Our ref: NO/2012/104042/01-L01
Your ref: 3/2012/0578
Date: 03 September 2012

Dear Mr Thorpe

DEVELOPMENT OF OUTDOOR ADVENTURE CENTRE, ERECTION OF BUILDING TO PROVIDE TICKETING, CUSTOMER SERVICE FACILITIES, TOILETS, RESTAURANT AND CAFE, COVERED SEATING AREAS AND ANCILLARY RESTILS SALES. CONSTRUCTION OF NEW ACCESS TO THE A671 WITH PARKING FOR 50 CARS, 5 COACHES TOGETHER WITH CYCLE AND MOTORCYCLE PARKING AND ASSOCIATED ROADS AND LANDSCAPING DEVIL'S ELBOW, LAND OFF WHALLEY ROAD (A67), READ

Site Layout

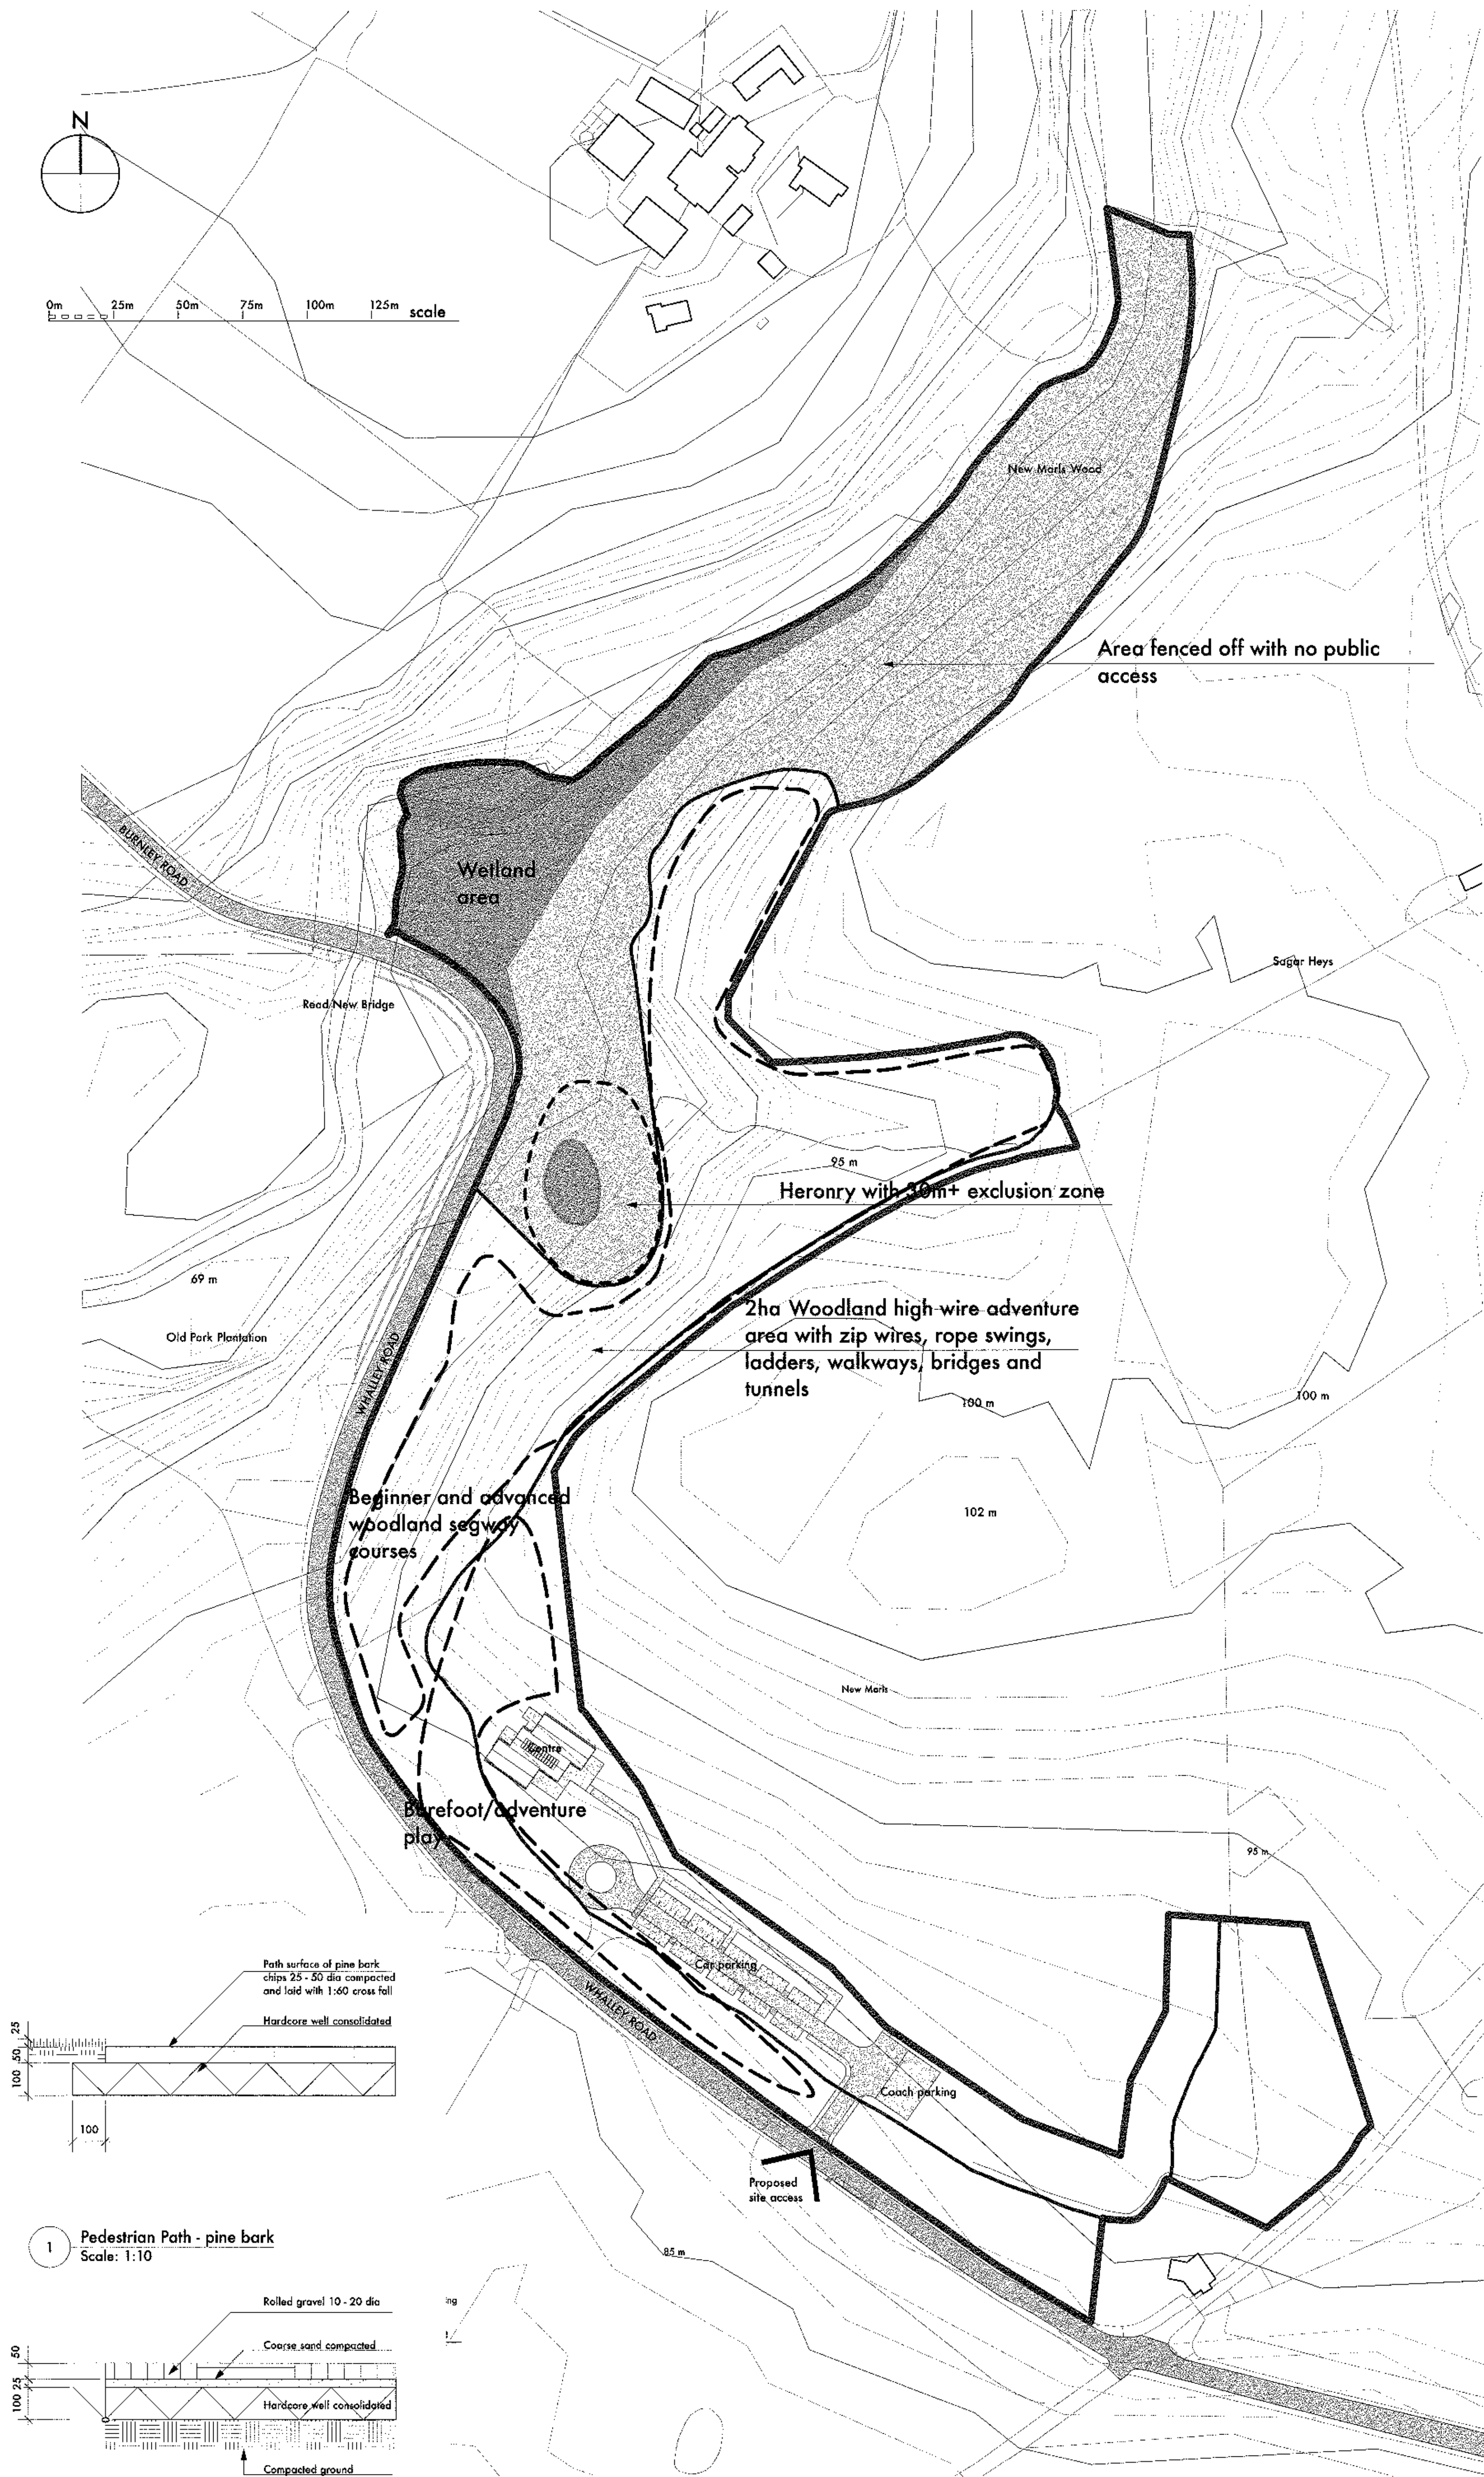
- Management of aquatic habitats
- The footprint of the development and distance to the brook and wetlands (including existing and proposed footpaths)
- Mitigation and enhancement details and timing of works
- How an annual litter cleanup is sufficient for a BHS with increased visitor numbers
- proposed changes or impacts in hydrology of the site, including runoff from buildings, car parks, and prevention or mitigation measures

Sabden Brook adjoining the site is a designated Main River and is therefore subject to Land Drainage Byelaws. In particular, no trees or shrubs may be planted, nor fences, buildings, pipelines or any other structure erected within 8 metres of the top of any bank/retaining wall of the watercourse without prior written Consent of the Environment Agency. Full details of such works, together with details of any proposed new surface water outfalls, which should be constructed entirely within the bank profile, must be submitted to us for consideration.
